Please ask for: Ms Iqraa Malik
Email: iqraa.malik@terraquest.co.uk
Telephone: 0121 234 1390
Our Ref: FP/59/22/HH
Your Ref:
Date: 13th April 2022

Application for Planning Permission for Works or Extension to a Dwelling

Development: Demolition of existing rear elevation conservatory, side elevation porch and front wall.
Construction of new rear and side elevation single storey extension. Construction of new lower level wall to front to provide additional off street parking. Rendering of front, side and rear elevation. Cladding of all elevations with Cedral boarding.

Location: Beach House Havelock Close Felpham PO22 7AY

PROPOSED BOUNDARY WALL

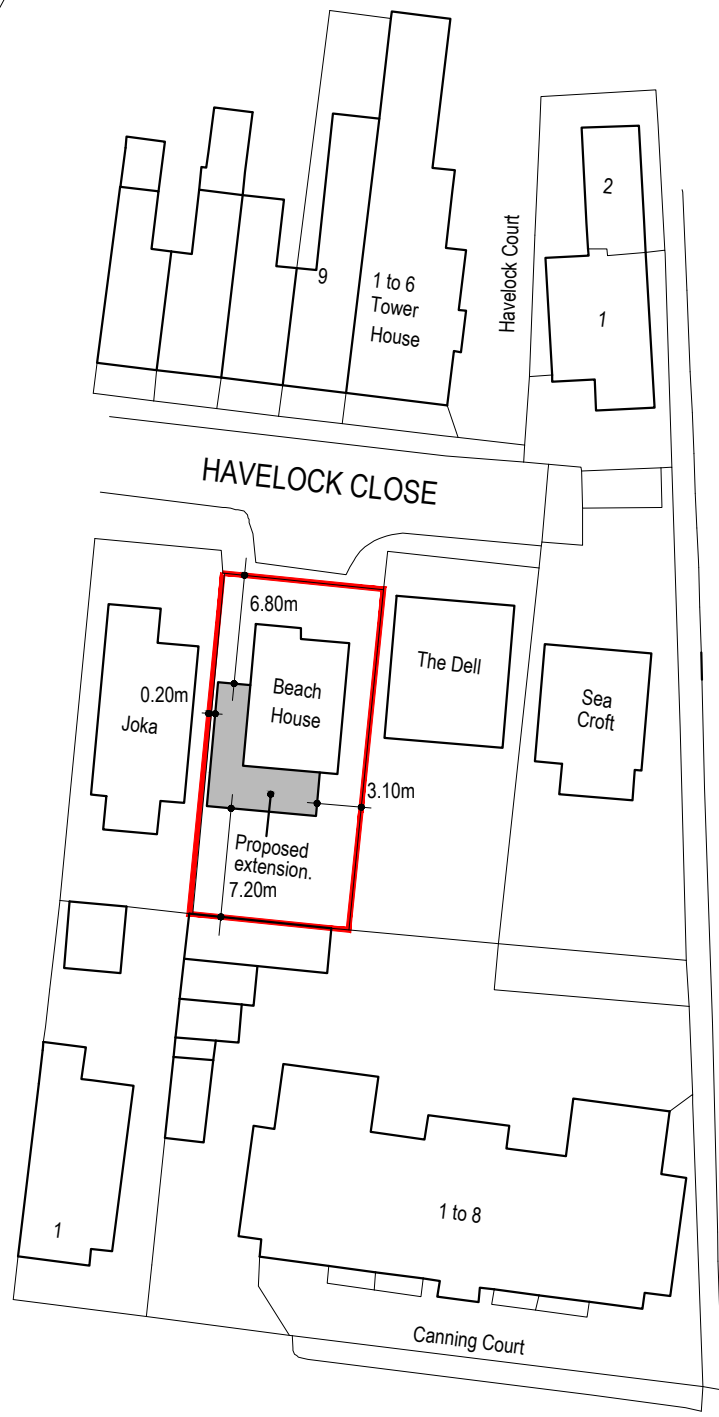
Wall: You are required to include an elevation of the wall showing the maximum height.
